**Aquind Interconnector application for a Development Consent Order
for the 'Aquind Interconnector' between Great Britain and France
(PINS reference: EN020022)**

**WRITTEN SUBMISSIONS IN RELATION TO ISSUE SPECIFIC
HEARING 1 INTO THE DRAFT DEVELOPMENT CONSENT ORDER**

Submitted in relation to Deadline 5 of the Examination Timetable

TITLE: Application document reference 2.6  
Converter Station and Telecommunications  
Buildings Parameter Plans  
Combined Options  
Sheet 1 of 3

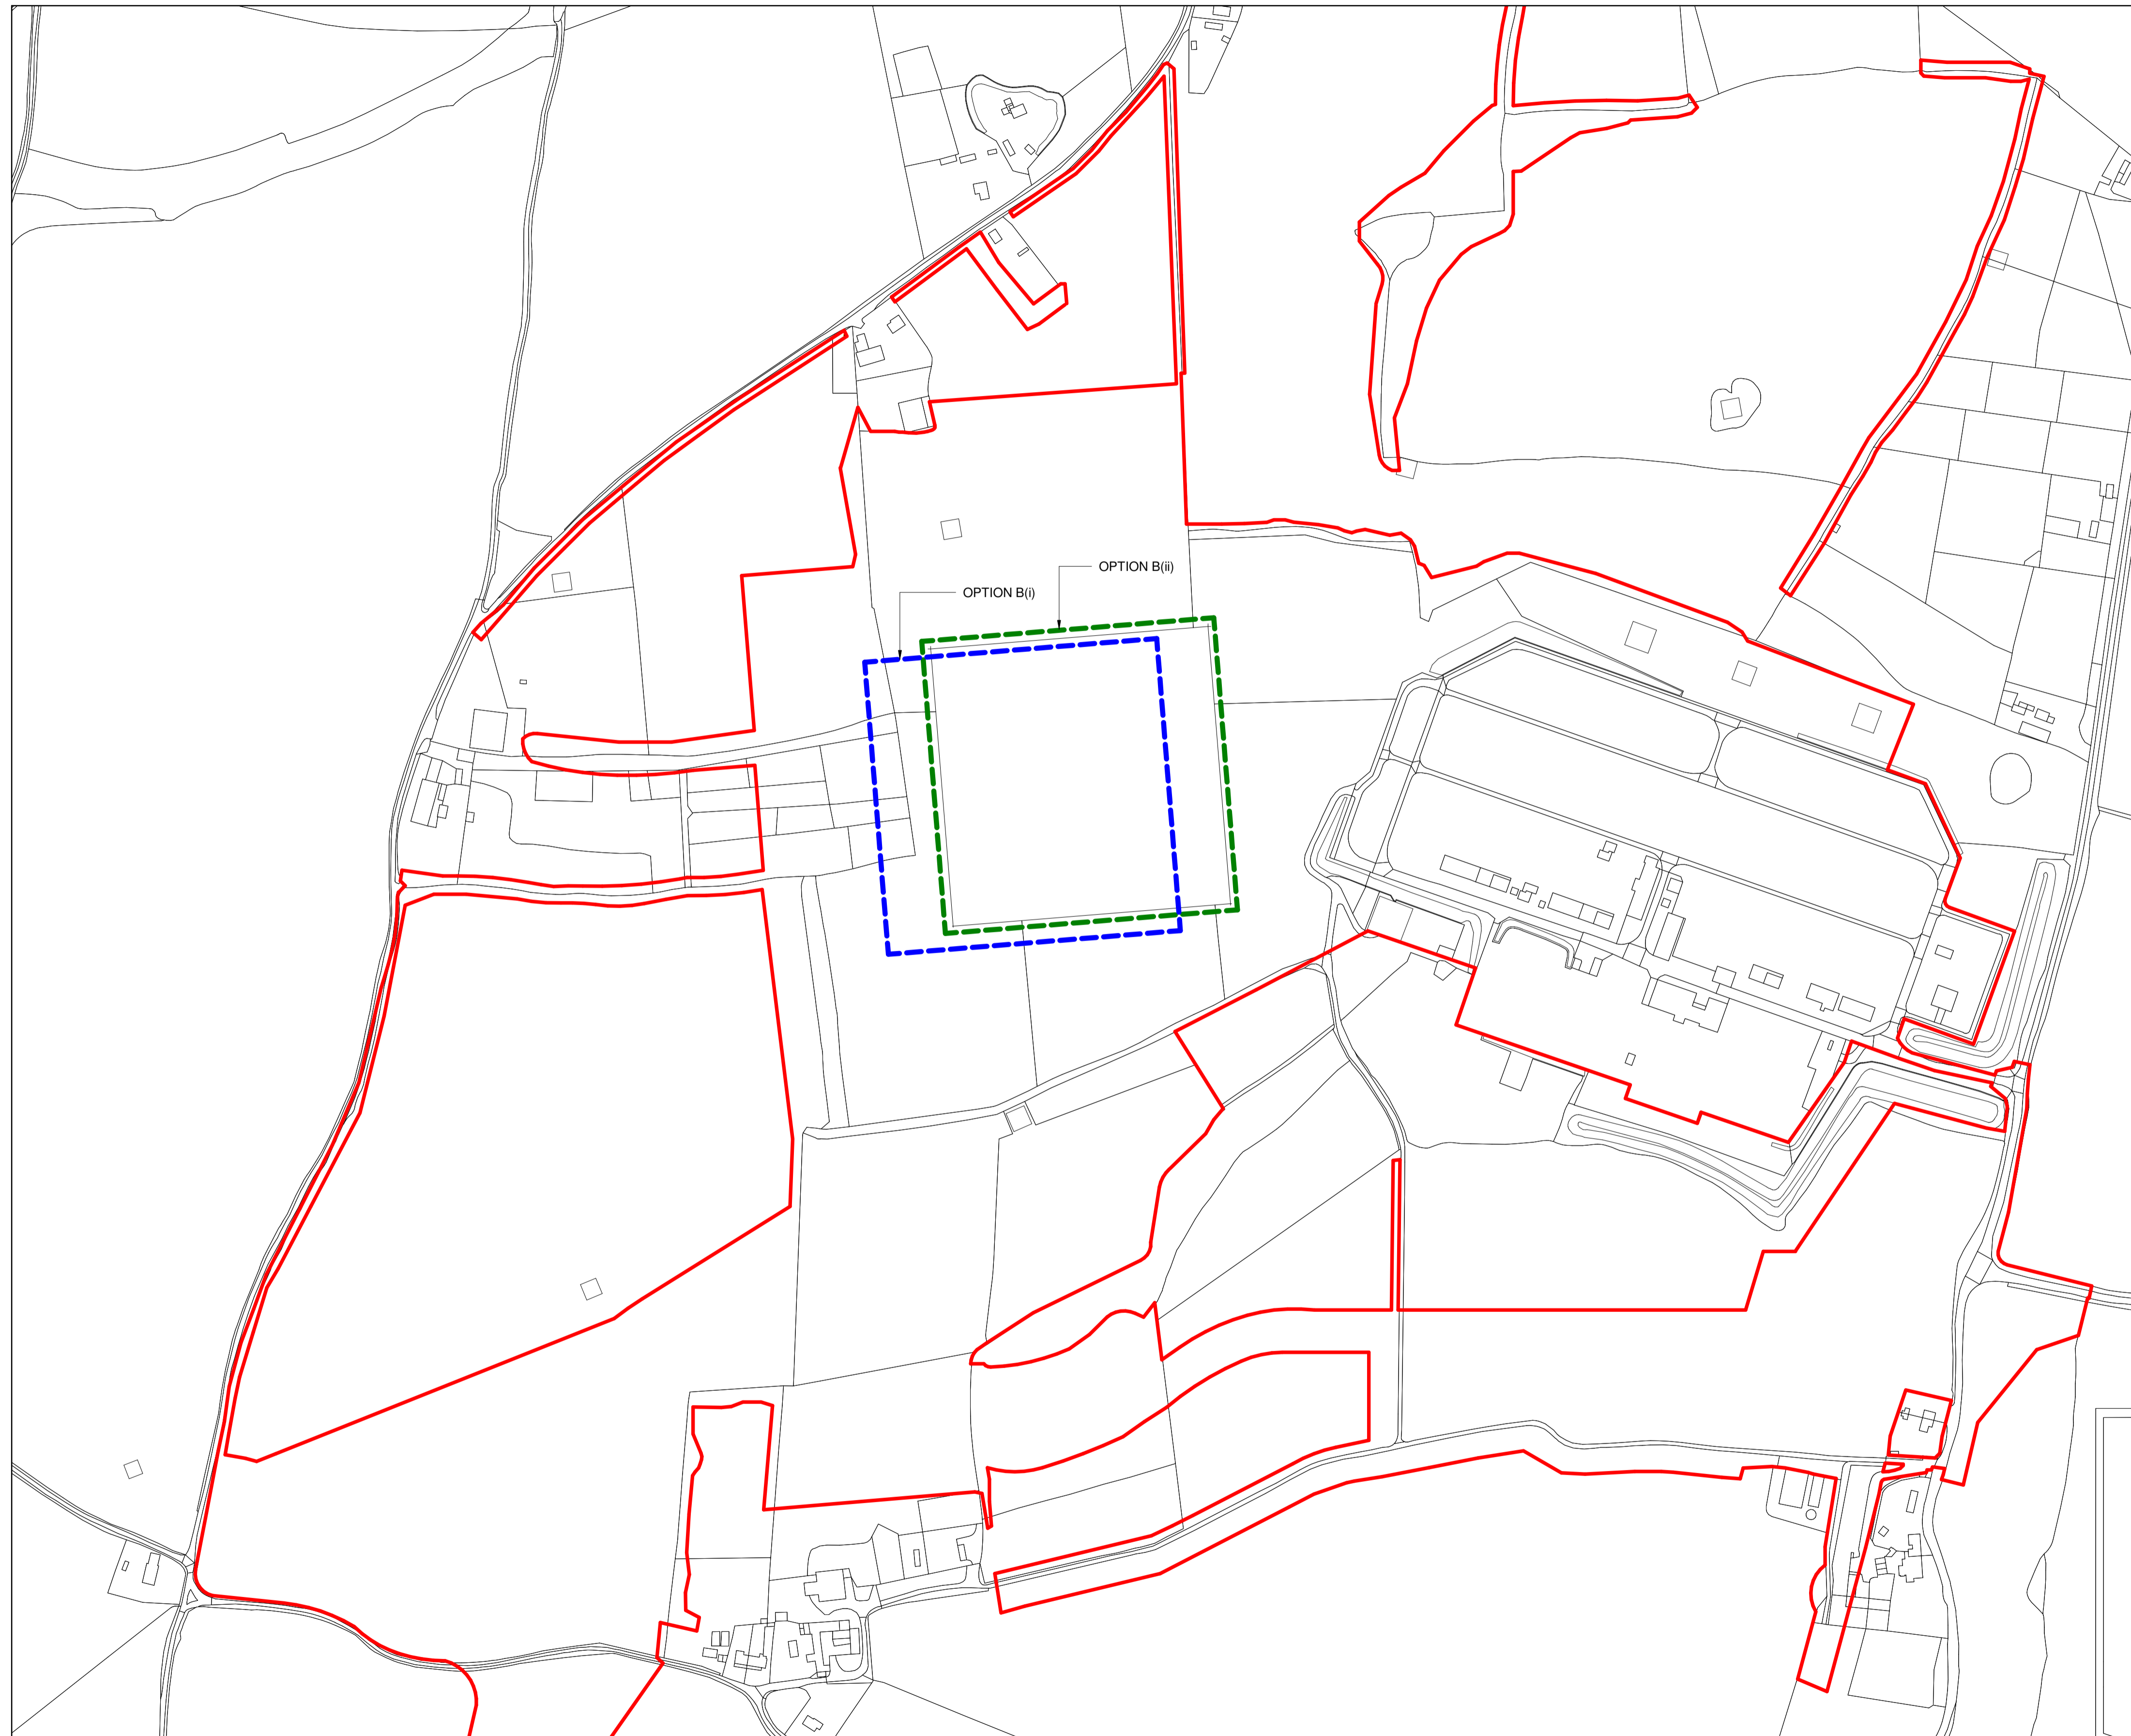
Provision in of Draft DCO (version as submitted by the Applicant at Deadline 3)	Required Amendment	Justification for Required Amendment					
	Drawing number EN020022-2.4WP-Sheet1	Proposed Protective Provisions for Little Denmead Farm.	<p>of document reference REP4-047 Representations for Deadline 4 by Mr. Geoffrey Carpenter and Mr. Peter Carpenter (Registration Identification Number: 20025030).</p> <p>In relation to our Clients' land generally in relation to Schedule 5 Works plans these should be read and amended in the context of the proposed protective provisions submitted at Deadline 5 and the full justification submitted with them.</p>					
24	<p>Schedule 7 Parameter Plans</p> <p>Drawing Number EN020022-2.6-PARA-Sheet1</p>	<p>DELETE the words "<i>and Telecommunications Buildings</i>" from the Column headed <i>Drawing Title</i>:</p> <table border="1"> <tr> <td><i>EN020022-2.6-PARA-Sheet1</i></td> <td><i>02</i></td> <td><i>Converter Station and Telecommunications Buildings Parameter Plans Combined Options - Sheet 1 of 3</i></td> <td><i>1:1,250</i></td> <td><i>A1</i></td> </tr> </table>	<i>EN020022-2.6-PARA-Sheet1</i>	<i>02</i>	<i>Converter Station and Telecommunications Buildings Parameter Plans Combined Options - Sheet 1 of 3</i>	<i>1:1,250</i>	<i>A1</i>	<p>The inclusion of fibre optic telecommunication cables for commercial purposes does not satisfy the relevant legal tests for being "Associated Development". The Telecommunications Buildings are exclusively required in relation to that commercial purpose and so are not otherwise required.</p>
<i>EN020022-2.6-PARA-Sheet1</i>	<i>02</i>	<i>Converter Station and Telecommunications Buildings Parameter Plans Combined Options - Sheet 1 of 3</i>	<i>1:1,250</i>	<i>A1</i>

Provision in of Draft DCO (version as submitted by the Applicant at Deadline 3)	Required Amendment	Justification for Required Amendment					
		<table border="1"> <tr> <td></td> <td></td> <td></td> <td></td> <td></td> </tr> </table>						<p>Please see the following documents for a fuller account of our position in relation to this:</p> <p>See column 4 of paragraphs 8 and 10 of Schedule 1 of document reference REP4-047; column 3 of paragraphs 2 and 7 of Schedule 2 of document reference REP4-047; and Schedule 4 of document reference REP4-047 Representations for Deadline 4 by Mr. Geoffrey Carpenter and Mr. Peter Carpenter (Registration Identification Number: 20025030).</p>
25	<p>Schedule 7 Parameter Plans</p> <p>Drawing Number EN020022-2.6-PARA-Sheet1</p>	<p>AMEND Drawing Number EN020022-2.6-PARA-Sheet1 to remove the Telecommunications Buildings from it</p>	<p>The inclusion of fibre optic telecommunication cables for commercial purposes does not satisfy the relevant legal tests for being "Associated Development". The Telecommunications Buildings are exclusively required in relation to that commercial purpose and so are not otherwise required.</p>

TITLE: Application document reference  
2.6 Converter Station and Telecommunications Buildings Parameter Plans  
Option B(i)  
Sheet 2 of 3

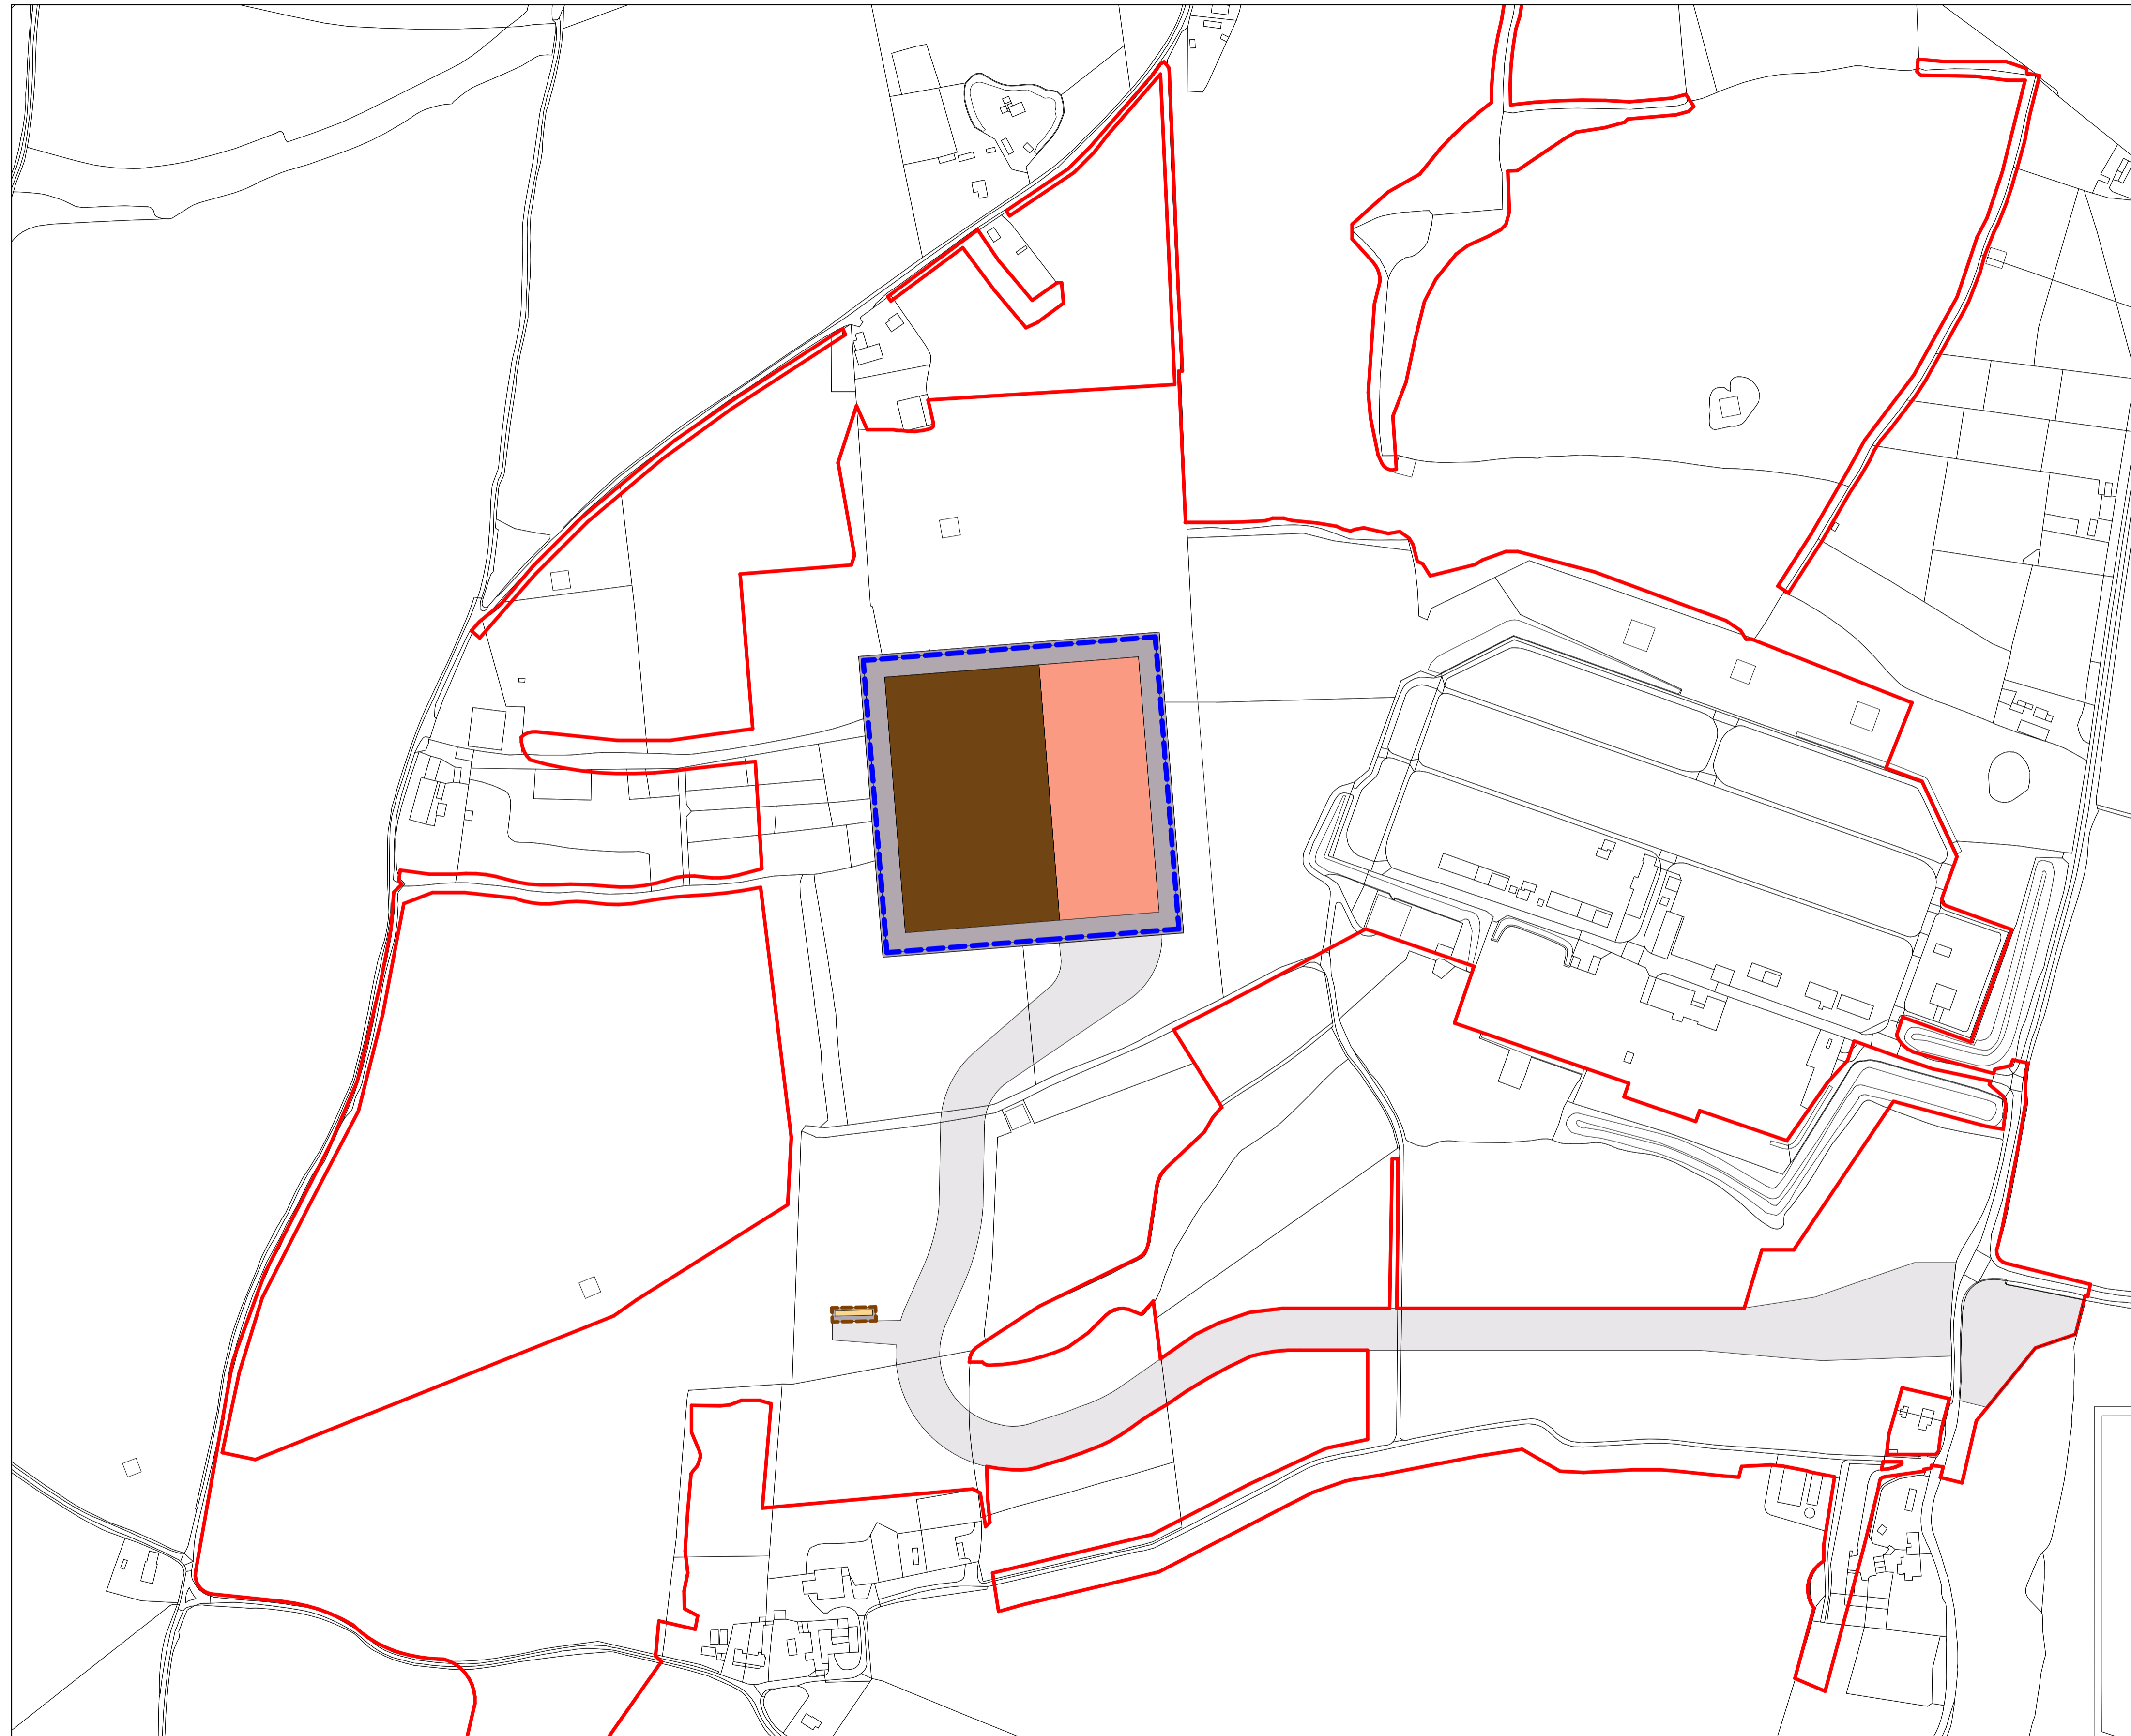
Provision in of Draft DCO (version as submitted by the Applicant at Deadline 3)	Required Amendment	Justification for Required Amendment					
			<p>Please see the following documents for a fuller account of our position in relation to this:</p> <p>See column 4 of paragraphs 8 and 10 of Schedule 1 of document reference REP4-047; column 3 of paragraphs 2 and 7 of Schedule 2 of document reference REP4-047; and Schedule 4 of document reference REP4-047 Representations for Deadline 4 by Mr. Geoffrey Carpenter and Mr. Peter Carpenter (Registration Identification Number: 20025030).</p>					
26	<p>Schedule 7 Parameter Plans</p> <p>Drawing Number EN020022-2.6-PARA-Sheet2</p>	<p>DELETE the words "and Telecommunications Buildings" from the Column headed <i>Drawing Title</i>:</p> <table border="1" data-bbox="638 1161 1420 1385"> <tr> <td data-bbox="638 1161 831 1385"><i>EN020022-2.6-PARA-Sheet2</i></td> <td data-bbox="831 1161 896 1385"><i>02</i></td> <td data-bbox="896 1161 1218 1385"><i>Converter Station and Telecommunications Buildings Parameter Plans Option B(i) - Sheet 2</i></td> <td data-bbox="1218 1161 1352 1385"><i>1:1,250</i></td> <td data-bbox="1352 1161 1420 1385"><i>A1</i></td> </tr> </table>	<i>EN020022-2.6-PARA-Sheet2</i>	<i>02</i>	<i>Converter Station and Telecommunications Buildings Parameter Plans Option B(i) - Sheet 2</i>	<i>1:1,250</i>	<i>A1</i>	<p>The inclusion of fibre optic telecommunication cables for commercial purposes does not satisfy the relevant legal tests for being "Associated Development". The Telecommunications Buildings are exclusively required in relation to</p>
<i>EN020022-2.6-PARA-Sheet2</i>	<i>02</i>	<i>Converter Station and Telecommunications Buildings Parameter Plans Option B(i) - Sheet 2</i>	<i>1:1,250</i>	<i>A1</i>

Provision in of Draft DCO (version as submitted by the Applicant at Deadline 3)	Required Amendment					Justification for Required Amendment
				<i>of 3</i>			<p>that commercial purpose and so are not otherwise required.</p> <p>Please see the following documents for a fuller account of our position in relation to this:</p> <p>See column 4 of paragraphs 8 and 10 of Schedule 1 of document reference REP4-047; column 3 of paragraphs 2 and 7 of Schedule 2 of document reference REP4-047; and Schedule 4 of document reference REP4-047 Representations for Deadline 4 by Mr. Geoffrey Carpenter and Mr. Peter Carpenter (Registration Identification Number: 20025030).</p>
27	<p>Schedule 7 Parameter Plans</p> <p>Drawing Number EN020022-2.6-PARA-Sheet2</p>	<p>AMEND Drawing Number EN020022-2.6-PARA-Sheet2 to remove the Telecommunications Buildings from it</p>					<p>The inclusion of fibre optic telecommunication cables for commercial purposes does not satisfy the relevant legal tests for being "Associated Development". The Telecommunications Buildings are exclusively required in relation to</p>
